Appendix E to the Relevant Representations of Natural England
Benthic and Intertidal Ecology

The construction and operation of the Five Estuaries Offshore Wind Farm located approximately 37km from the Suffolk Coast in the Southern North Sea.

Planning Inspectorate Reference EN010115

Appendix E – Benthic and Intertidal Ecology

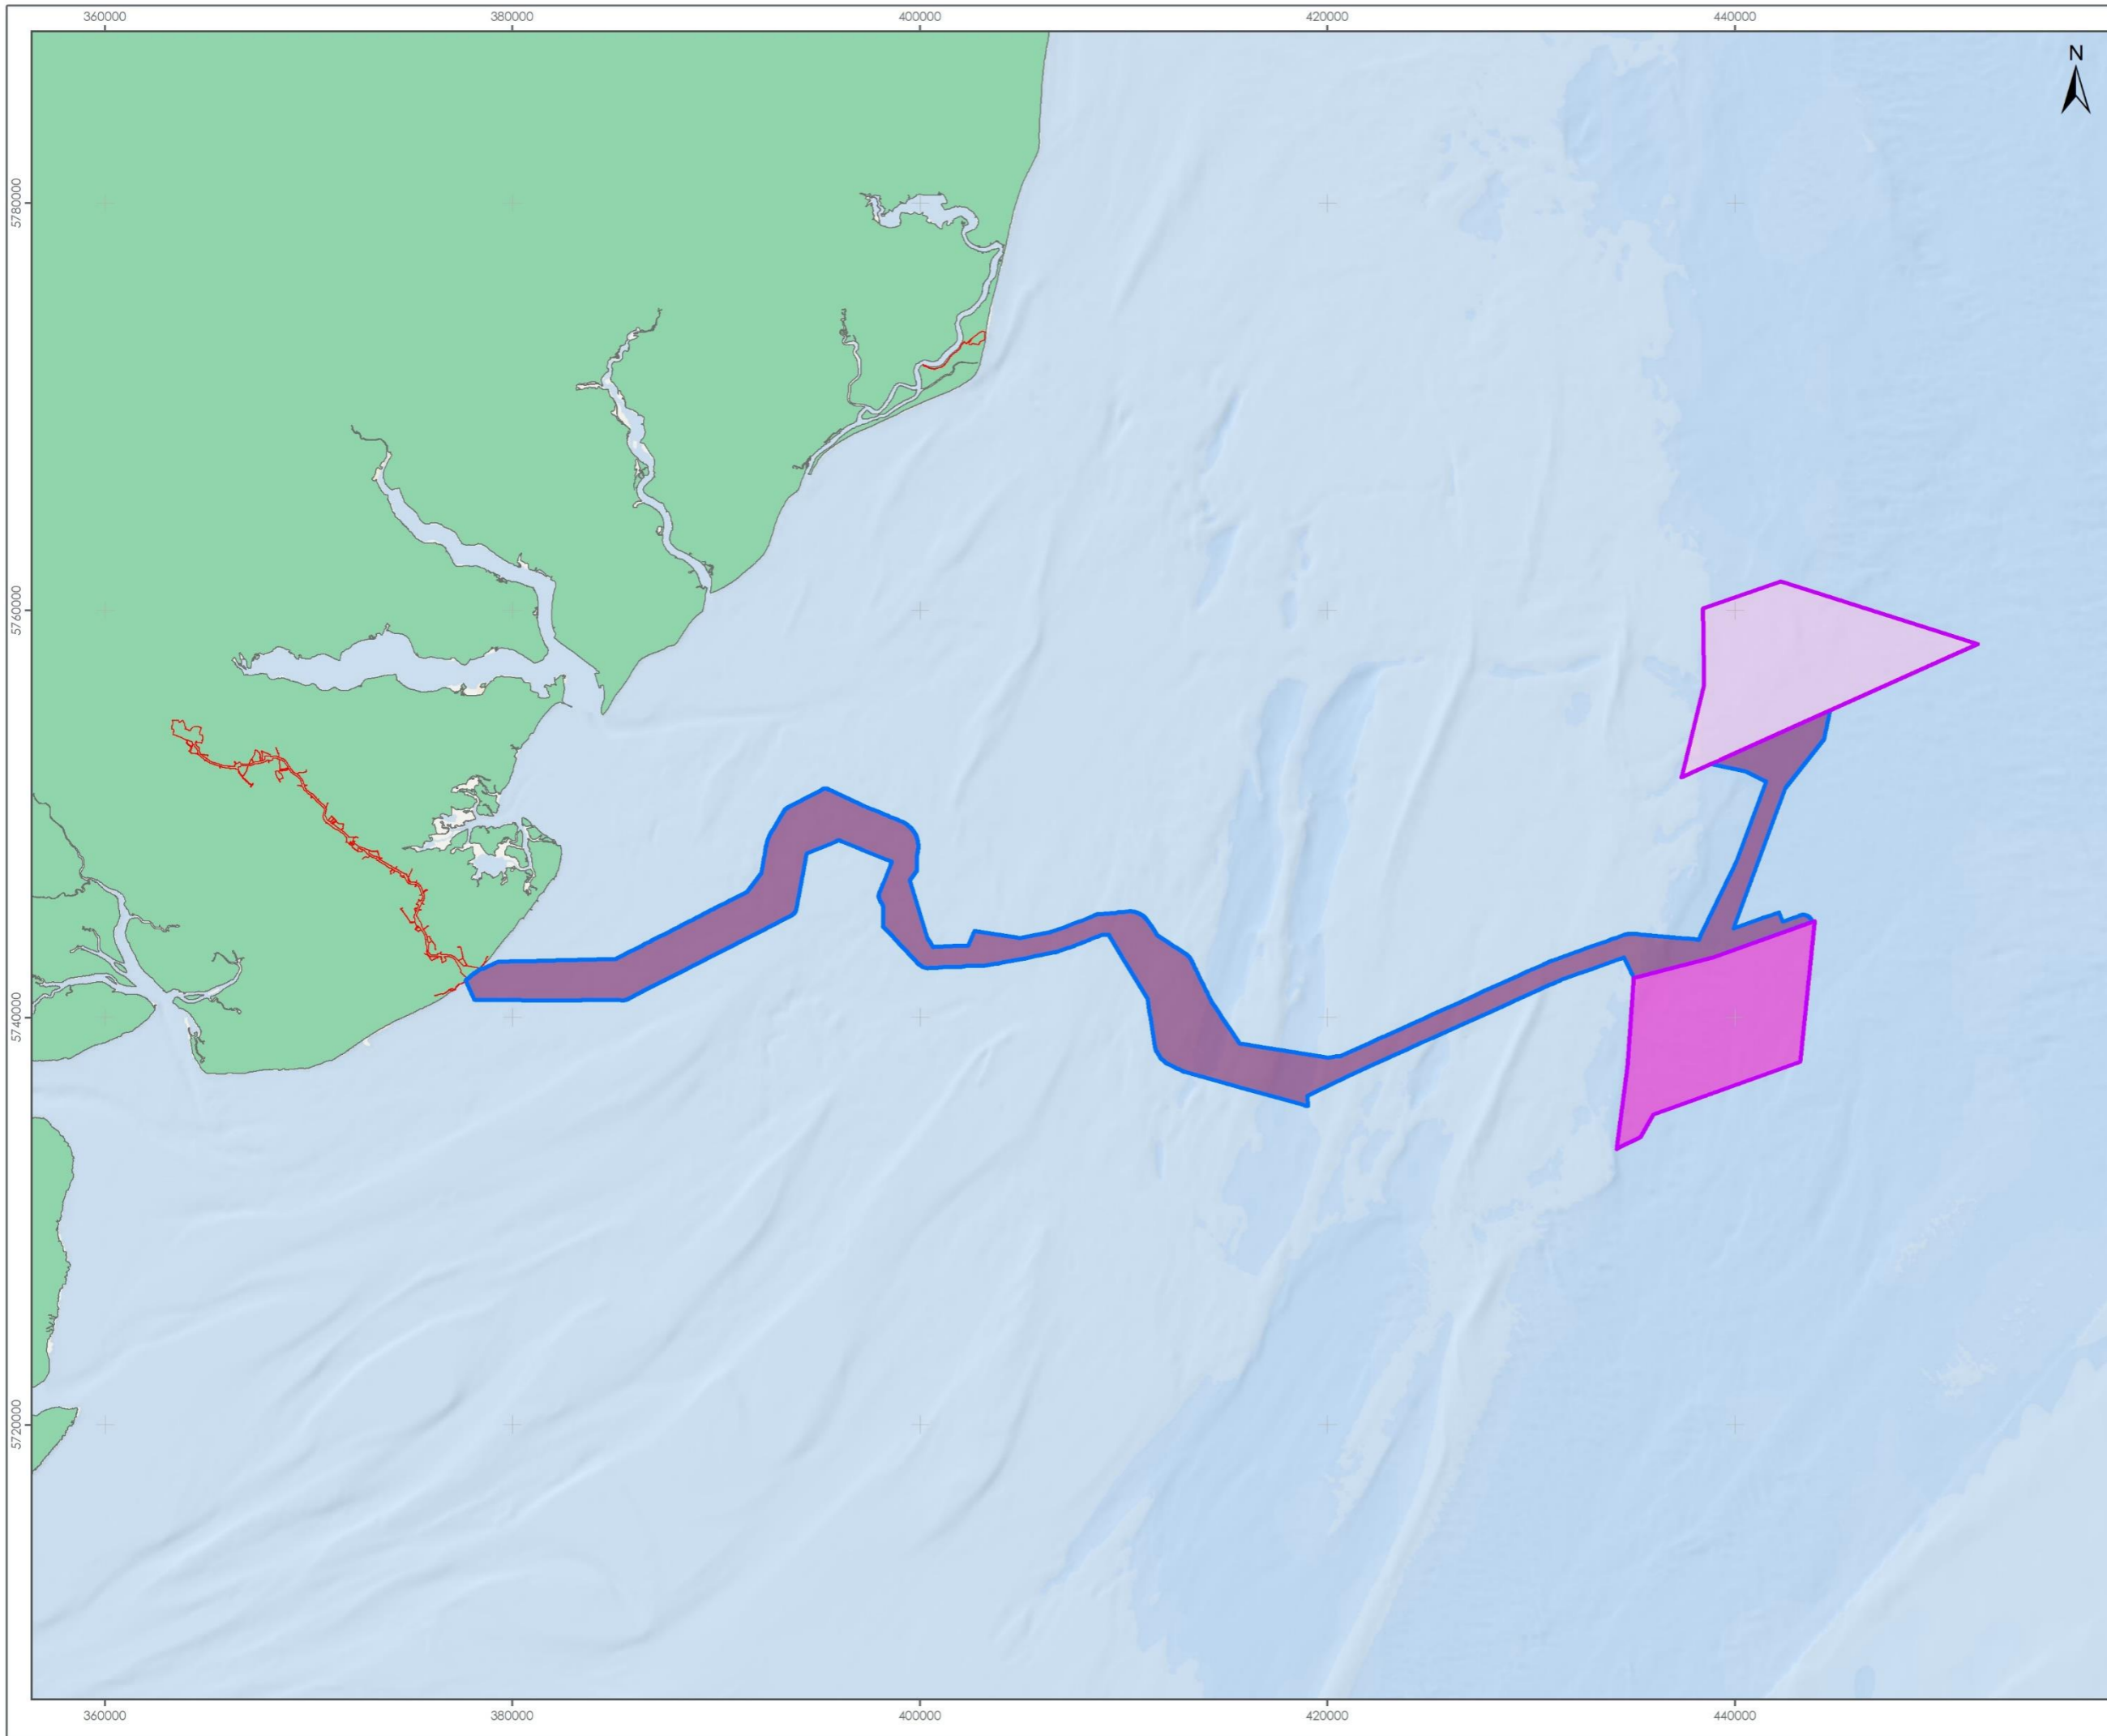
E9	APP-238 9.8	Natural England advises that parameters to determine the dredge disposal criteria other than within the same sediment type have not been included and therefore the WCS may not be realistic.	Natural England advises that in addition to being within same sediment type, commitments should also be made and secured to avoid priority areas and/or key areas of supporting habitats for mobile interest features of designated sites.

Natural England's Key Considerations	Natural England's Advice				
Relevant and Written Representations	NE Ref	Ref	Comment	Recommendation	Risk (RAG)
	E10	APP-238 9.8	Natural England highlights that evidence to support VE disposal activities includes those permitted and assessed in 2008 and due to the age of this evidence it can no longer be relied upon e.g. LID OWFs.	Natural England highlights that whilst we do not believe it will make a material difference to the assessment for this project, the evidence used would not normally be supported by the SNCBs as set out in the OWF best practice guidance .	
	E11	APP-238 9.8 Table 2.1 and 4.2.16	Natural England notes that there is no differentiation between disposal inside and outside of benthic designated sites. This also applies to what is being deposited and how to ensure that mitigation measures are fit for purpose.	Natural England advises that as mitigation for within designated sites should include deposition in areas with same sediment size/characterisation and use of a fall pipe rather than surface release.

E12	APP-238 9.8 6.2.15, 6.2.24	Natural England advises that all impact pathways should consider both EIA and HRA issues, with any disposal not interrupting sediment transport.	Natural England advises that mitigation measures should be considered from an EIA and HRA perspective and that monitoring should be secured to assess whether the residual impacts are as predicted and, if not, then remedial action should be undertaken.	
	E13	APP-242 9.12 4.5.2	Natural England advises that further mitigation measures should be adopted to differentiate between areas inside and outside of designated sites unless a precautionary approach is taken to all installation and operation activities within the assessment.	Natural England advises that the impacts from all types of external cable protection should be addressed refine down options and allow for a realistic WCS to be assessed.	
Baseline Characterisation - Document(s) Used: [APP-074] 6.2.5 Benthic and Intertidal Ecology

5 MAXIMUM LENGTH OF CABLE PROTECTION IN M&LS SAC

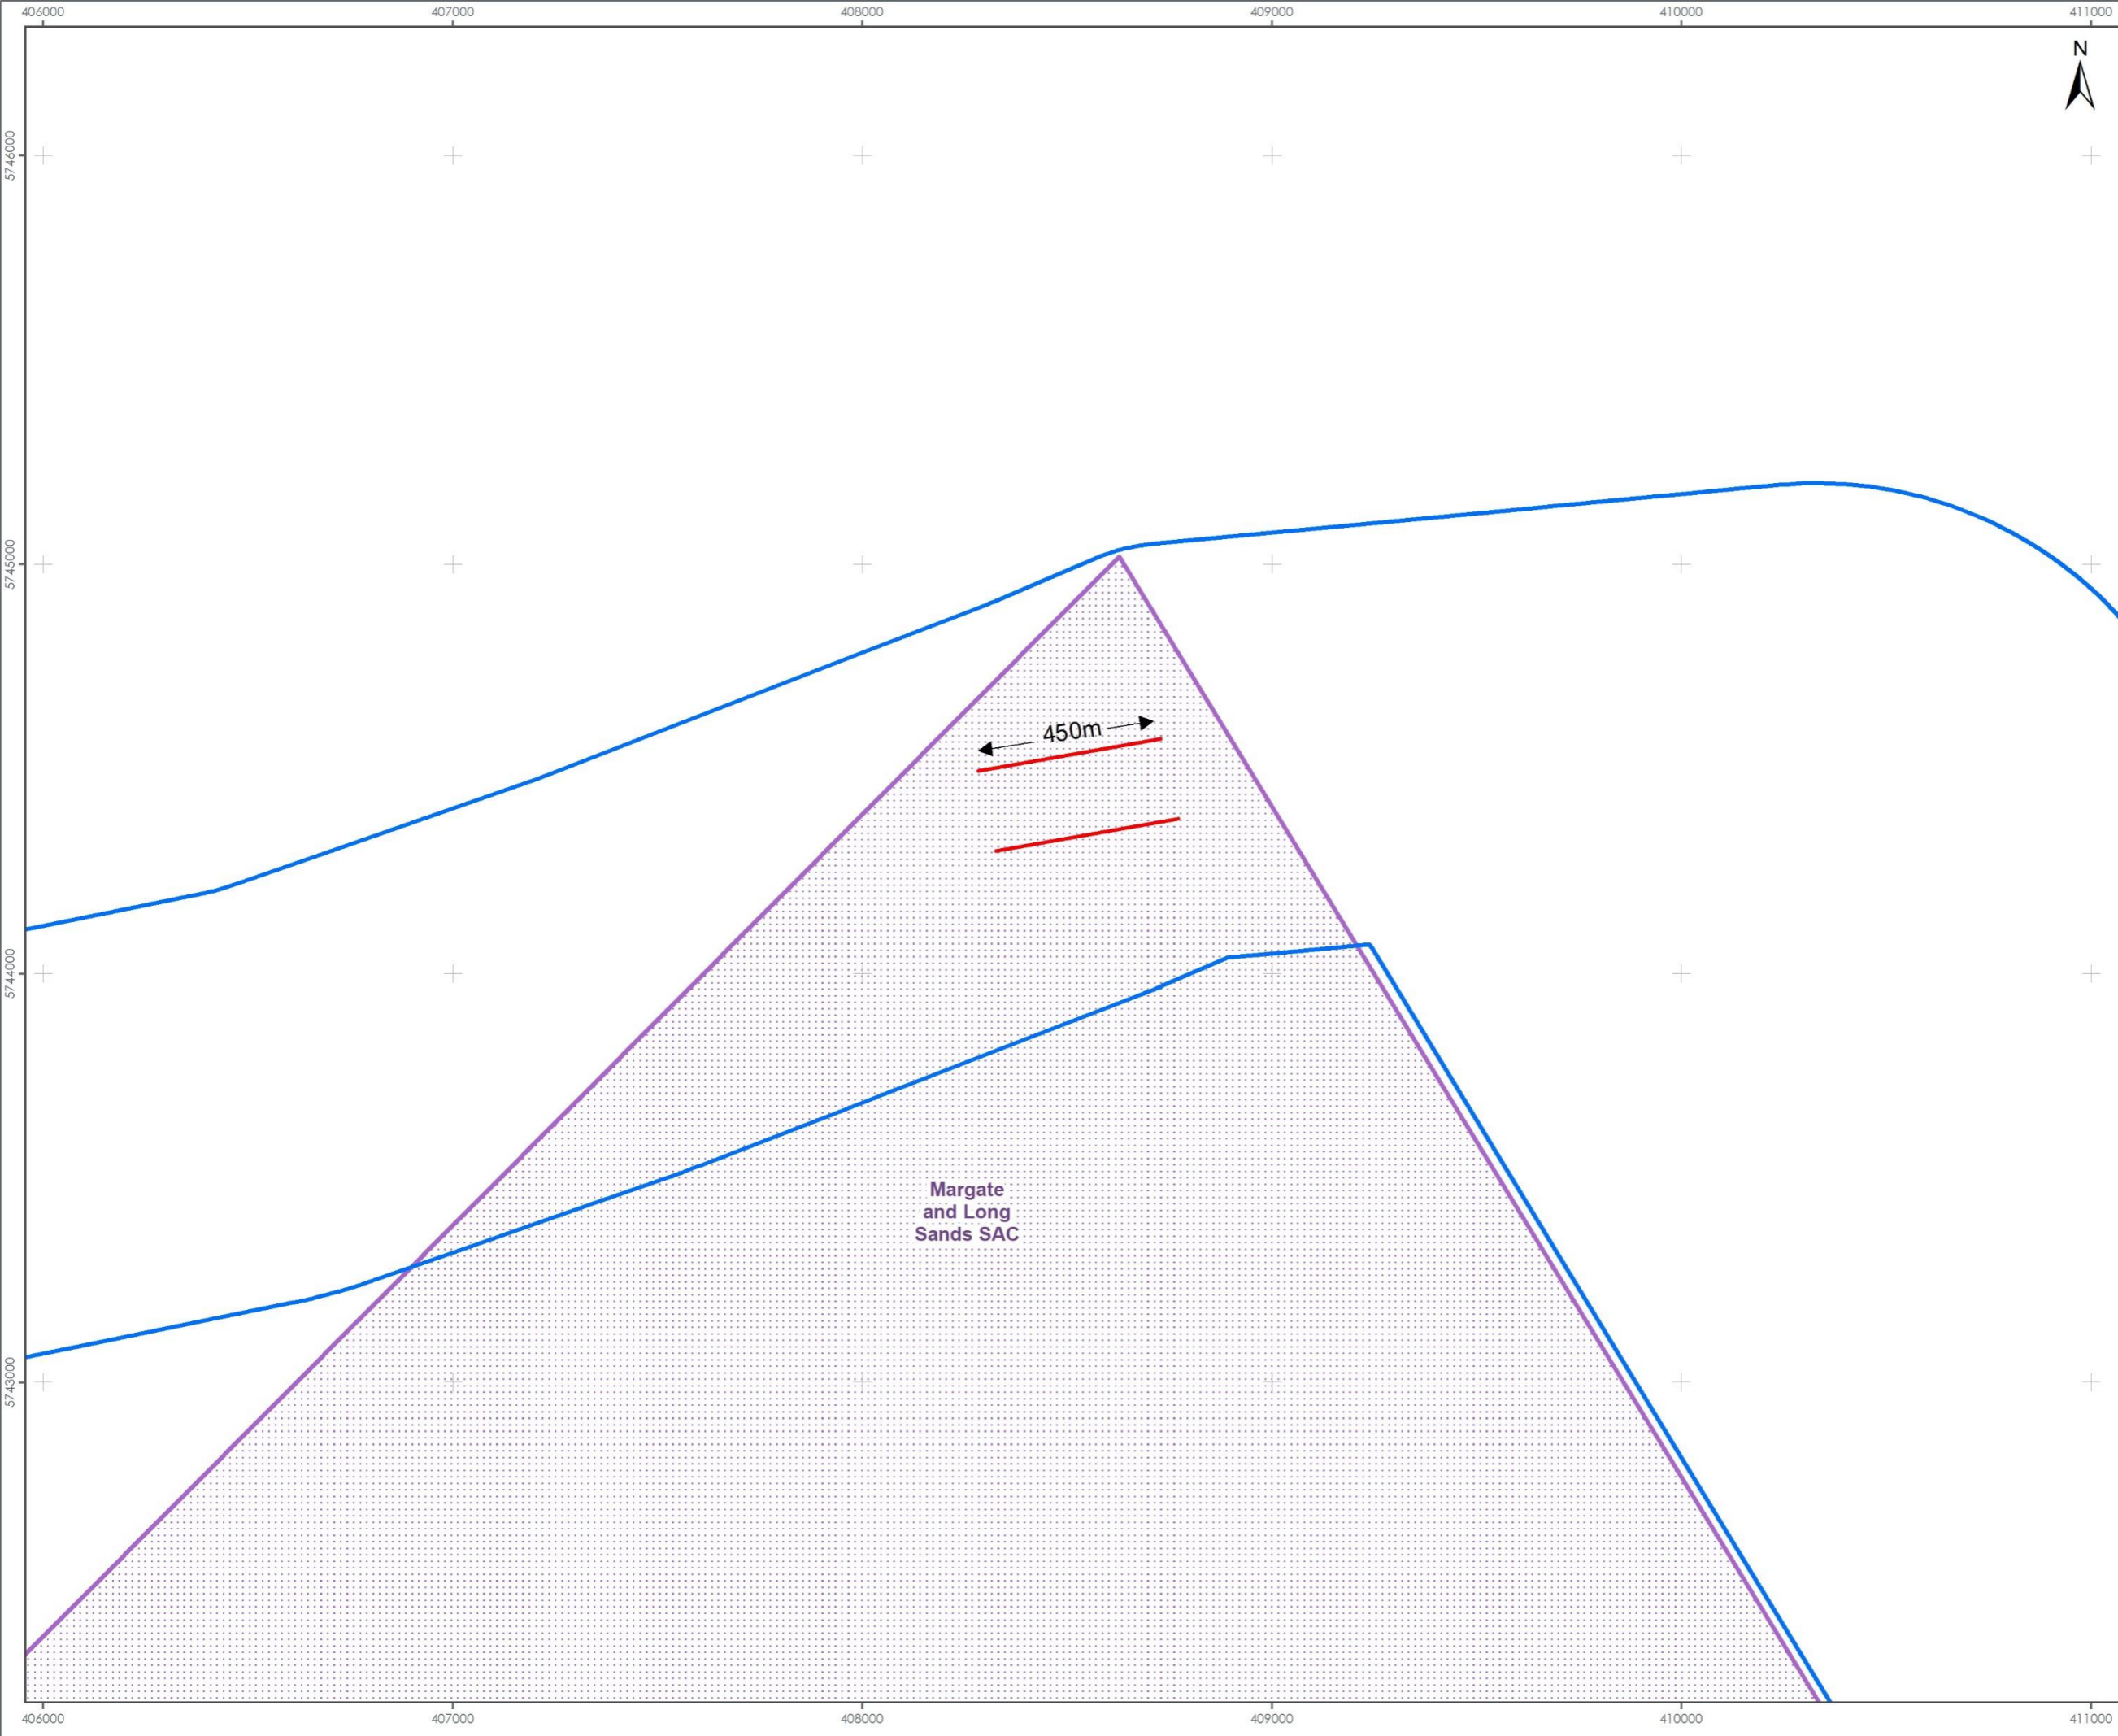
NE Ref	Summary of Key Concerns	Natural England's Recommendations to Resolve Issues.	Risk
E1	<p><u>Insufficient evidence</u> Natural England is concerned that the methods and information used to determine maximum length of cable protection within Margate and Long Sands Special Area of Conservation (MLS SAC) are not transparent and appear to be high level, and as such, it is not clear how realistic this Maximum Design Scenario (MDS) is. Natural England advises that due to uncertainty (reasonable scientific doubt) we cannot advise the exclusion of an Adverse Effect on Integrity (AEol). Therefore, there is a need to further quantify the impact to inform the levels of compensation required.</p>	<p>Natural England advises that further information is required to provide the necessary confidence in the MDS/Worst Case Scenario (WCS) for cable protection within the SAC.</p>	
E2	<p><u>Impacts on SPAs</u> Natural England notes that the Applicant's current assessments of pressures/impacts on supporting benthic habitats for Special Protection Area (SPA) features and impacts to prey availability lacks rationale and robustness.</p>	<p>Natural England advises that full consideration of the likely nature, extent, duration, and significance of impacts upon SPA supporting habitats and prey availability is required to inform a robust assessment of the likely impacts upon designated ornithological features.</p>

Natural England's Key Considerations	Natural England's Advice				
Relevant and Written Representations	NE Ref	Ref	Comment	Recommendation	Risk (RAG)
Natural England's Position on Worst Case Scenario or Scenarios	7	APP-242 9.12 & APP-239 9.9	<p>It is not clear to Natural England what information has been used to determine the maximum length of cable protection required within MLS SAC (i.e. 900 m). It is also not clear whether the potential for the addition of further cable protection has been considered and included within the calculations for MDS/WCS for scour protection within the SAC.</p> <p>These documents are written from an engineering perspective rather than from an ecological one trying to understand the impacts from sub optimally buried cables and potential impacts to designated sites.</p>	<p>In order that a meaningful assessment can be made, Natural England require the applicant to provide a transparent justification for the WCS quantification of benthic impacts within MLS SAC, drawing upon previous experience and available information about the ground type along the ECC route. The WCS should also include any possible post-construction measures such as the placement of additional scour replenishment.</p> <p>Natural England would welcome additional information relating to the WCS volume of cable protection (as well as the total cable length) within Margate and Long Sands SAC so that it is clear to all parties what the thresholds are. Natural England queries how the regulator will be certain that the WCS within the SAC has not been exceeded? If the Secretary of State (SOS) is minded to consent the project, further DCO/dML restrictions may be appropriate.</p>
